East Anglia ONE North and East Anglia TWO Offshore Windfarms

Applicants' Comments on William Halford's Deadline 8 Submission – Post hearing submission

Document Reference: ExA.AS-17.D9.V1

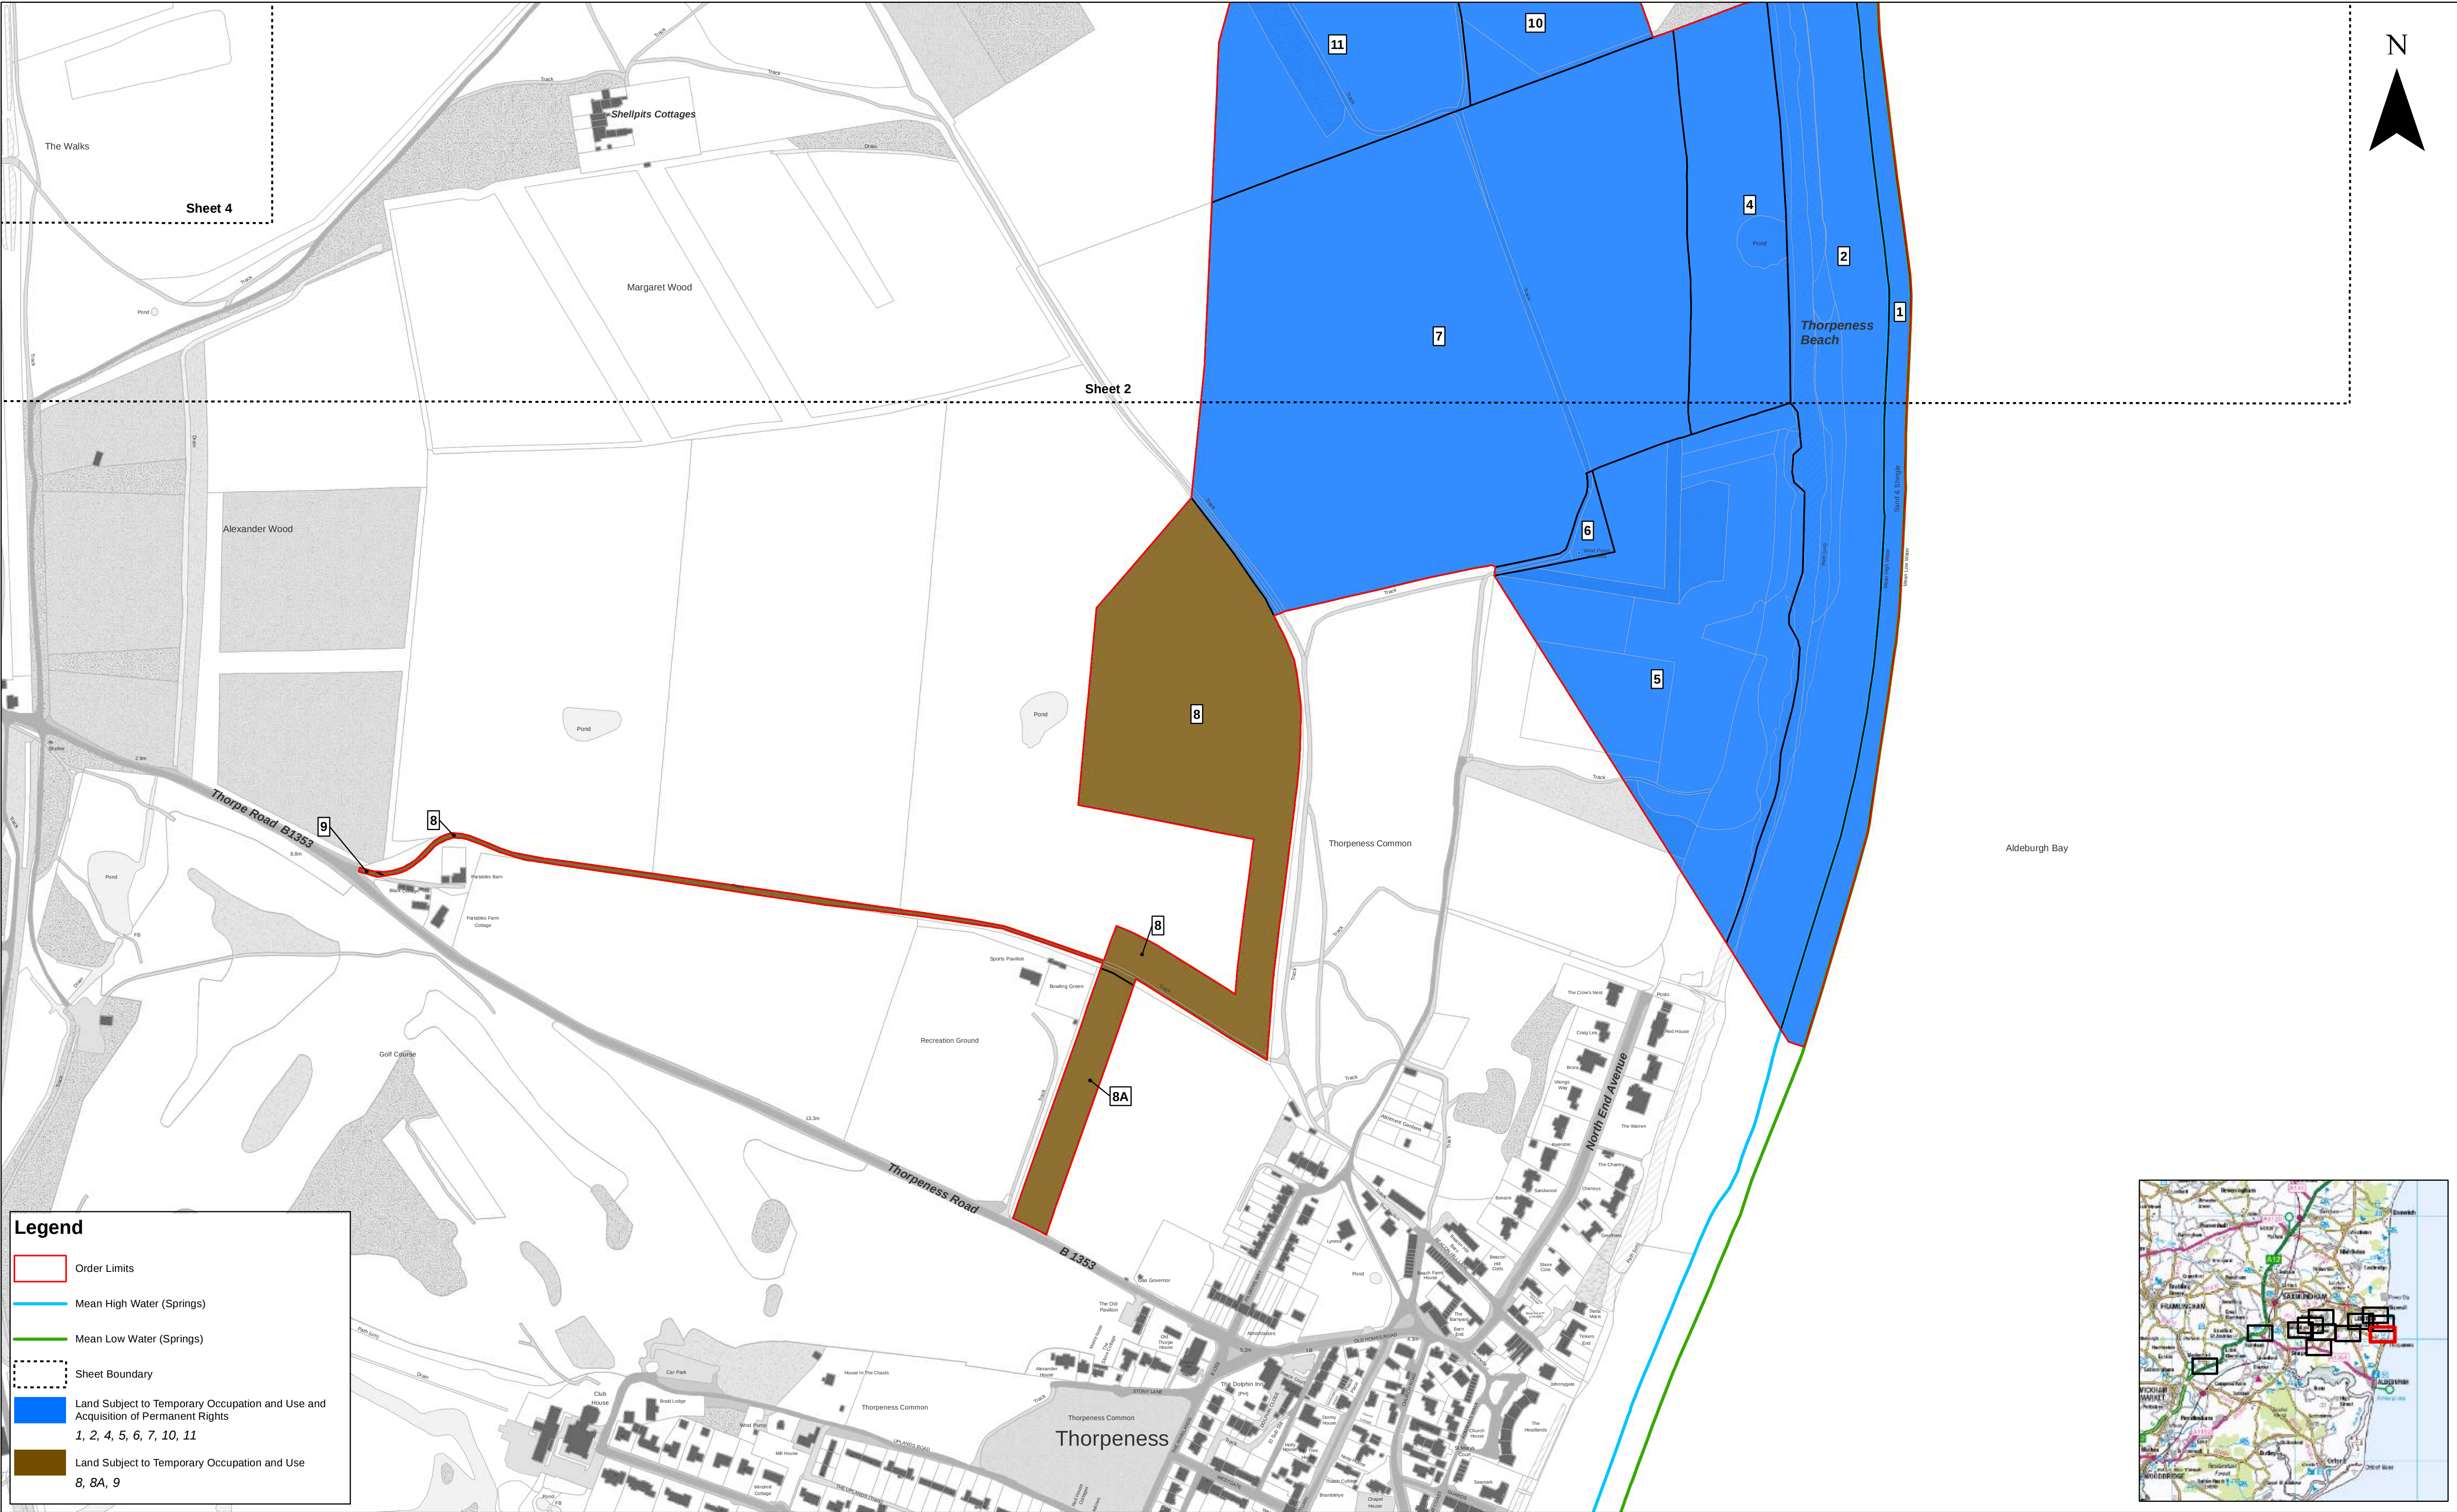
ID	William Halford's Comments	Applicants' Comments
	<p>7. Proximity to Order Limits</p> <ul style="list-style-type: none"> • The distance of the house from Cable Corridors Order Limit, according to 2.2 EA1N Land Plans (Onshore) - Rev 04, Sheet 5 are 71m at closest point. • The rear garden is only 26m away from Order Limit at its boundary with Hundred River. • Land Plan Rev 04 does not illustrate our main living area at the rear of the house, added in 2014. This extended the house 5m nearer to Works No 19 than the Land Plan shows. <p>8. EA1N/EA2 works activities anticipated to take place in proximity to the home</p> <ul style="list-style-type: none"> • Construction of one or two haul roads between Works Access 4 at B1353 and River Hundred • Trenching and laying of cable duct / cables along Cable Corridors • Construction of an Open Cut Watercourse crossing of the Hundred River and over pumping of river water during that process • Repeated turnings of HGV and other construction vehicles on East side of Hundred River <p>9. Other factors</p> <ul style="list-style-type: none"> • A major contributor to the market value of this house has been its quiet, rural wooded location alongside the Hundred River and with views across attractive meadows of the Aldringham River Hundred SLA. • The only separation of the rear wooded garden from the meadow on the East side of the river at Works 19 is the river itself. The width of the river varies according to season and rainfall. The land is designated by Environment Agency as Flood Zone 3 and is highly prone to fluvial flood. Consequently, it has not been practicable or desirable for the owners to build a visual/ noise barrier such as a boundary fence at the rear garden boundary. • [Text redacted], our days are largely spent in the garden and in the house according to season. Construction noise, dust and visual intrusion on this residence from construction works and vehicles will inevitably blight our lives during construction. 	<p>10. Under normal circumstances the Applicants would have been in attendance however due to health regulations and guidance were not permitted to attend on this occasion.</p> <p>11. The Book of Reference gives addresses for owners of individual plots of land identified within the Book of Reference as being affected by the Projects. The Applicants have included those addresses only for this reason.</p>
